From: Roxanne Navrides
To: [Lauren Anderson](#); [Robin Proebsting](#)
Subject: SUB19-002 2825 West Mercer Way
Date: Wednesday, April 17, 2019 8:25:01 AM

3/1/19
 JOB NUMBER:
13-118
 SHEET NAME:
SP-01
 SHT **3** OF **9**

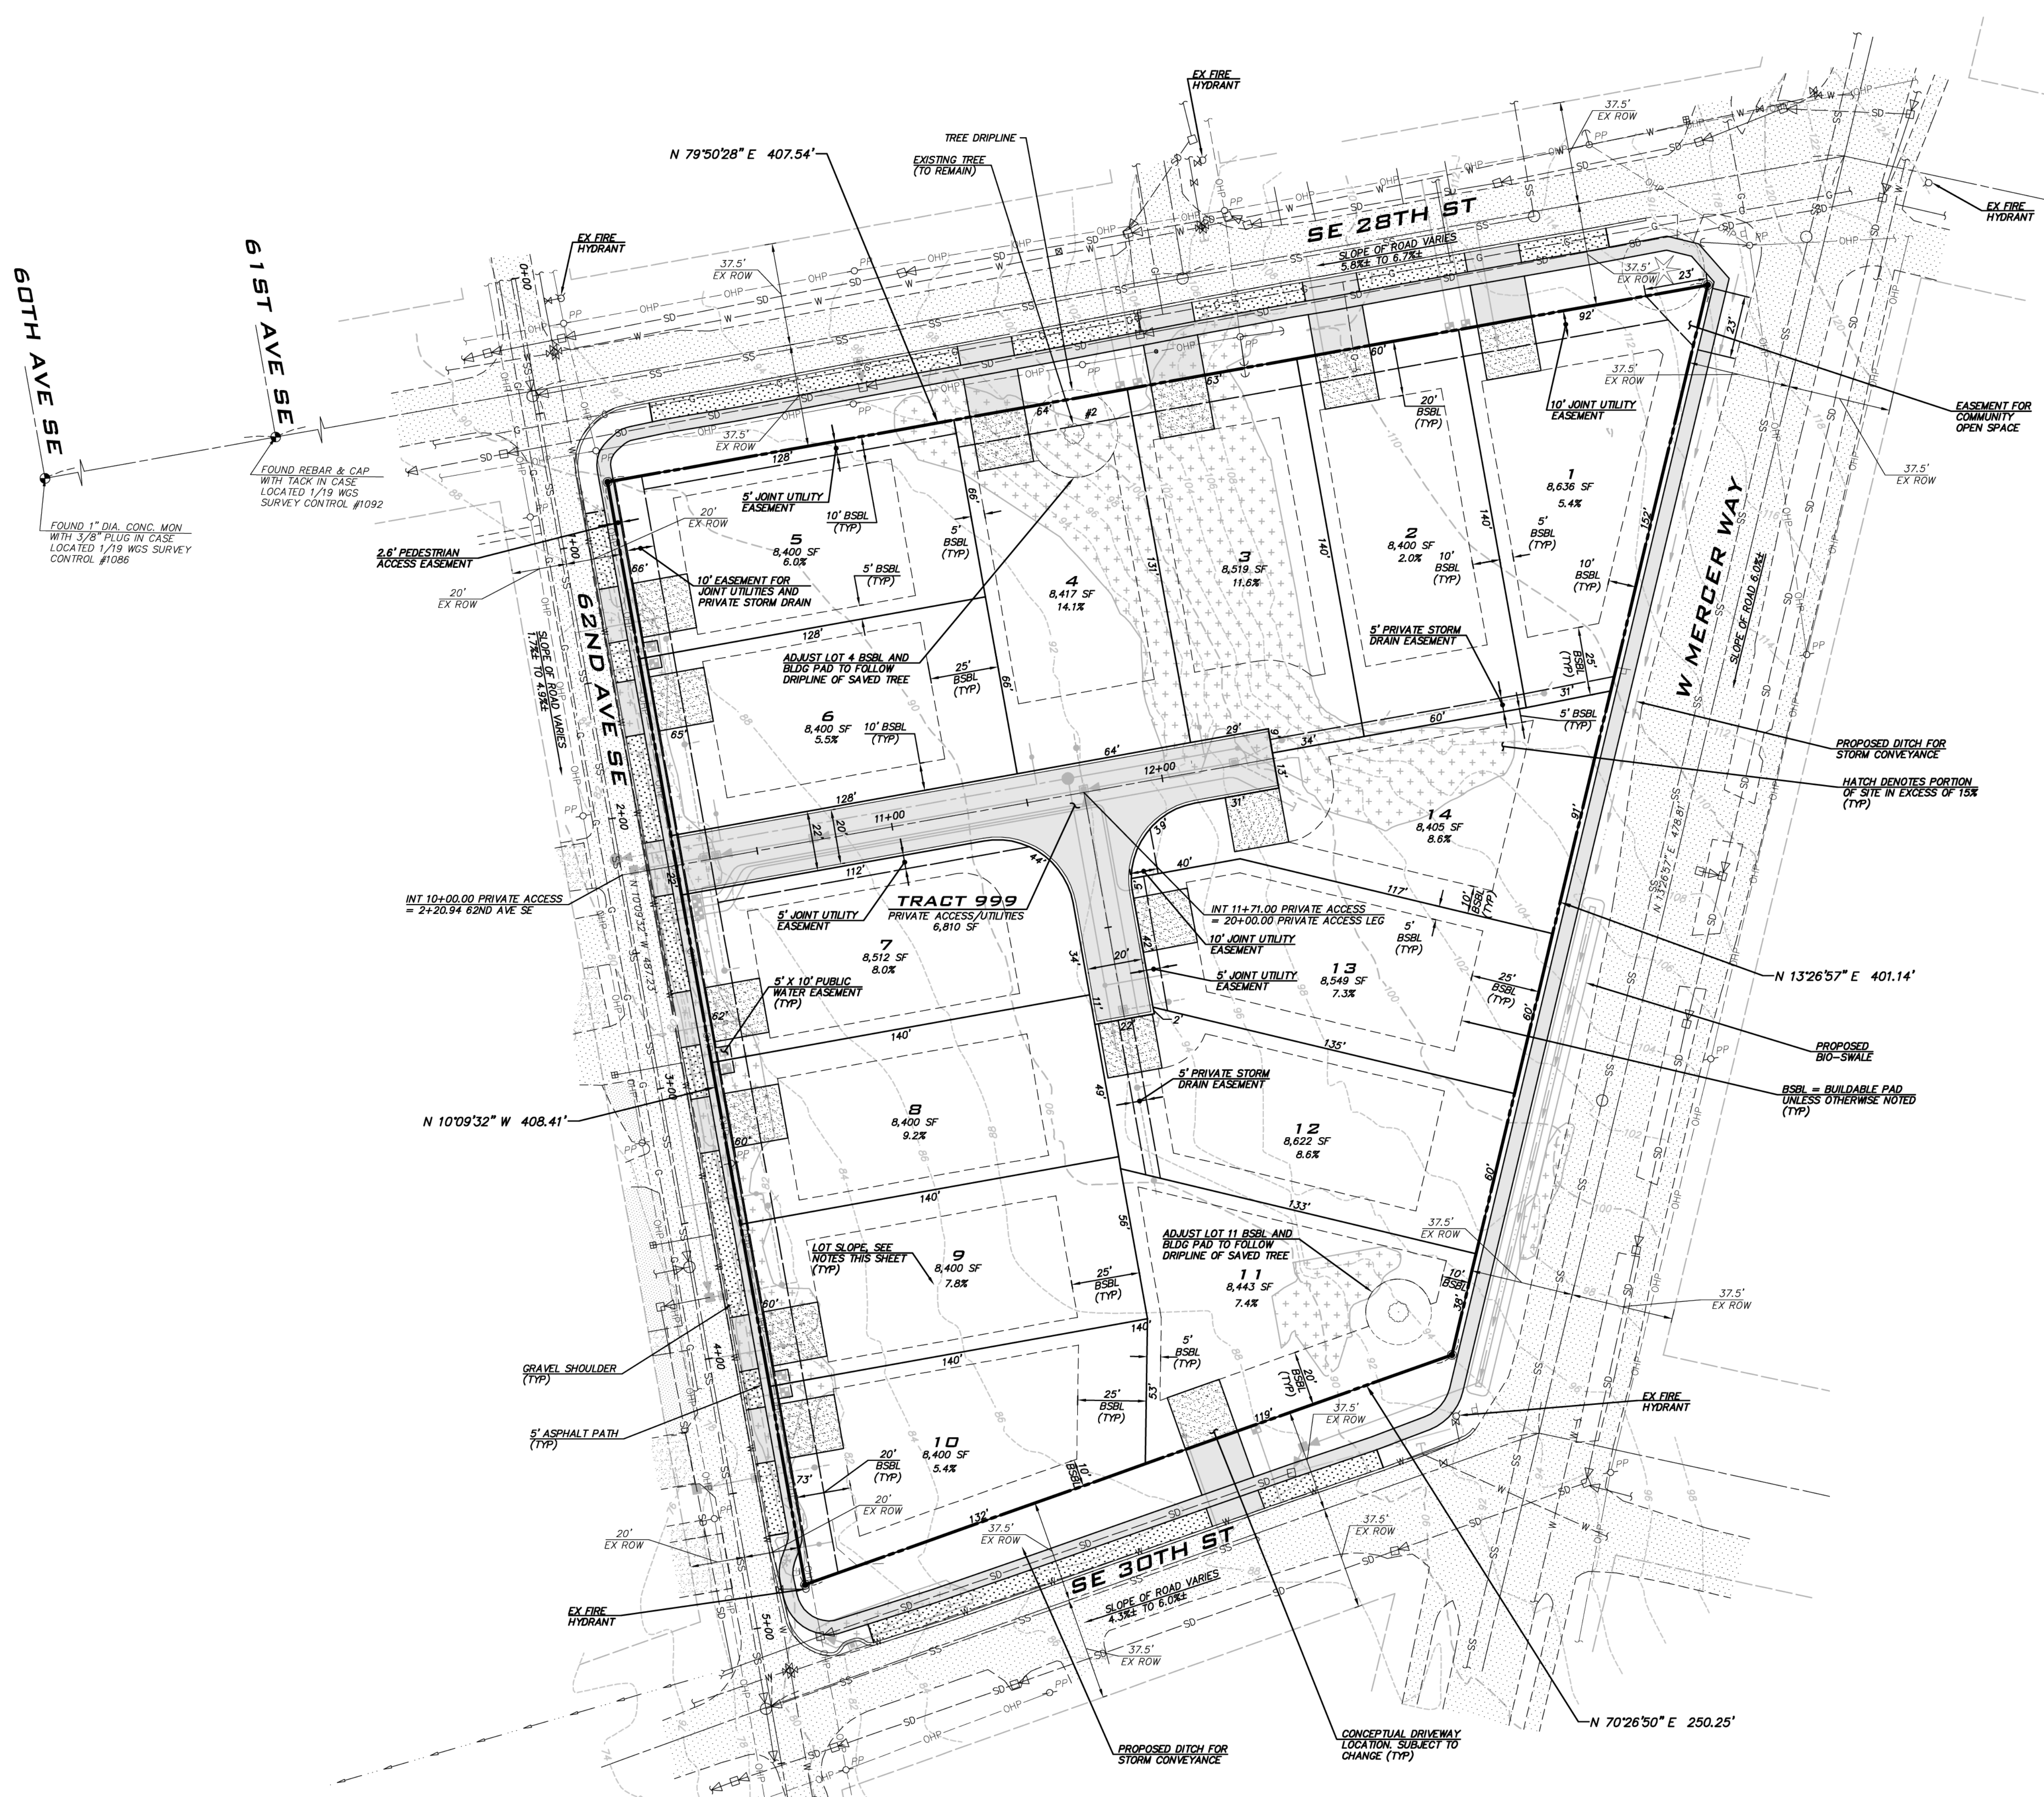
There is NO OPEN space, albeit it is mentioned. While this site legally accommodates 14 homes, it looks to be far too tight a fit to be viable for this neighborhood. It would be prudent to reduce it to twelve and provide some open space. The yards look extremely tiny which is not consistent with our neighborhood, as you can see from looking across the street and in the area

3/1/19
JOB NUMBER:
13-118
SHEET NAME:
GP-01
SHT **4** OF **9**

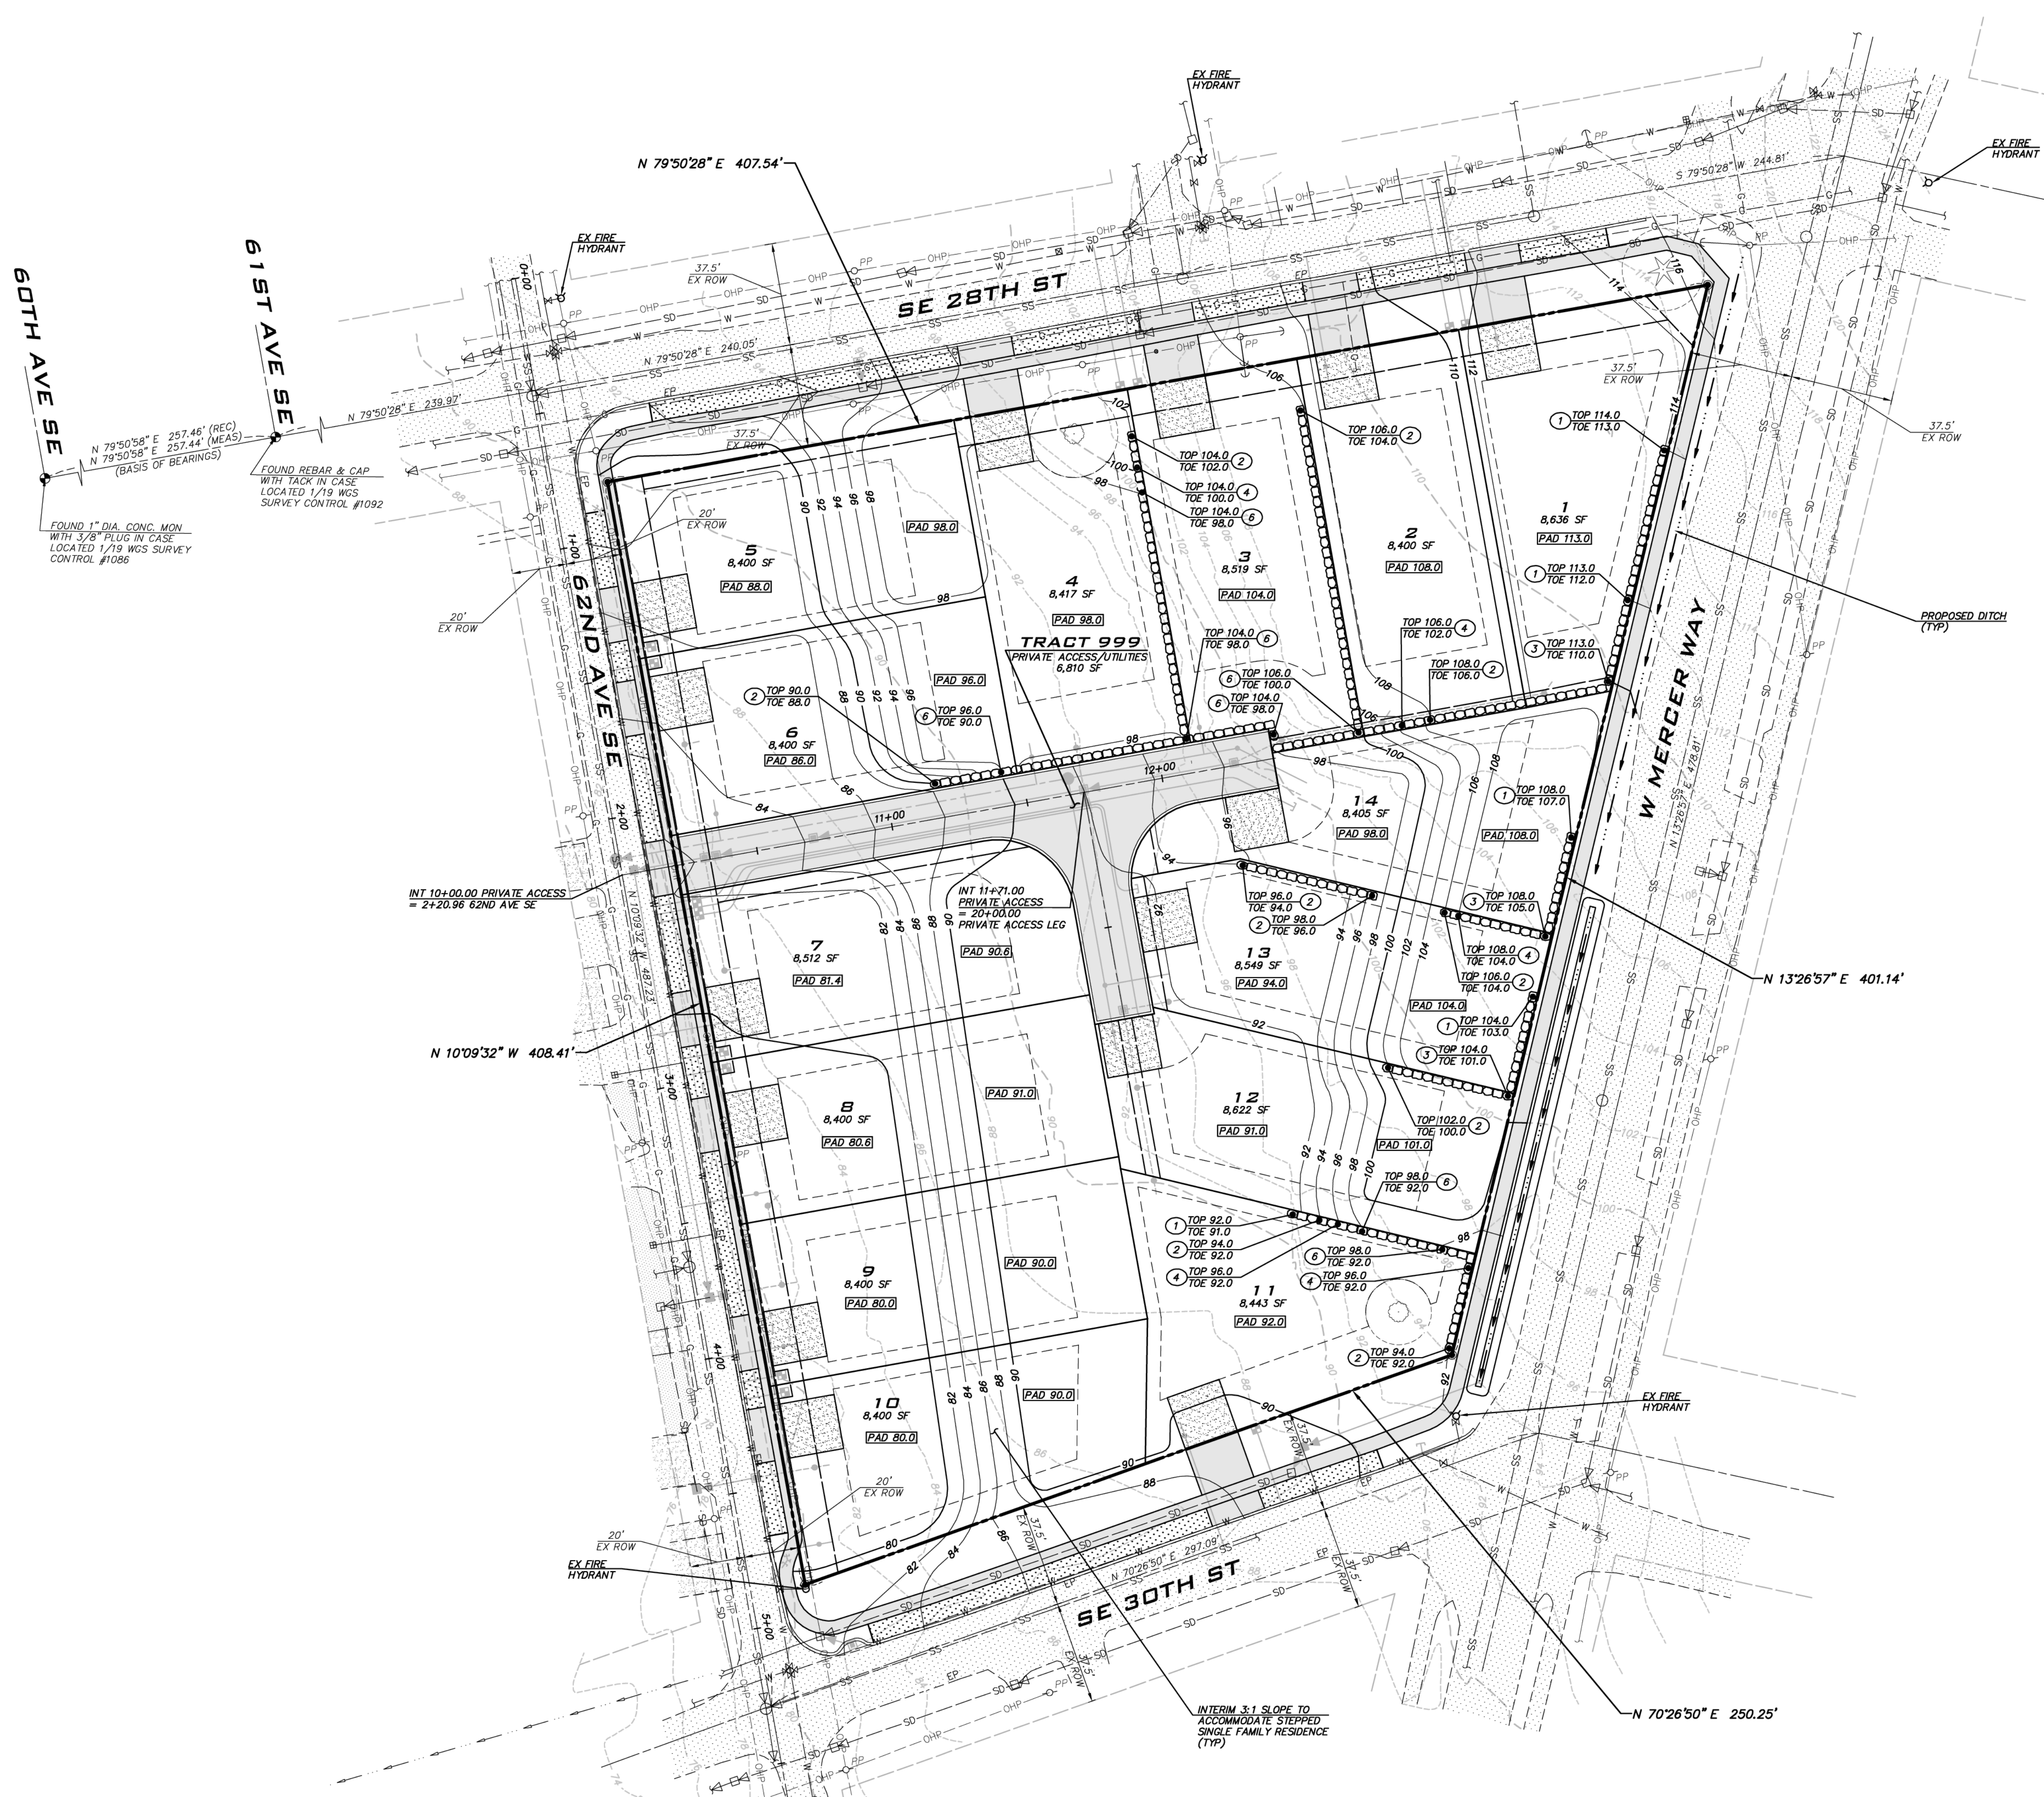
Second, while I realize there is a 30 foot height limit, it is imperative that the existing grade IS NOT RAISED to provide “higher height” homes. This would negatively affect all surrounding homes and would not be consistent with the neighborhood
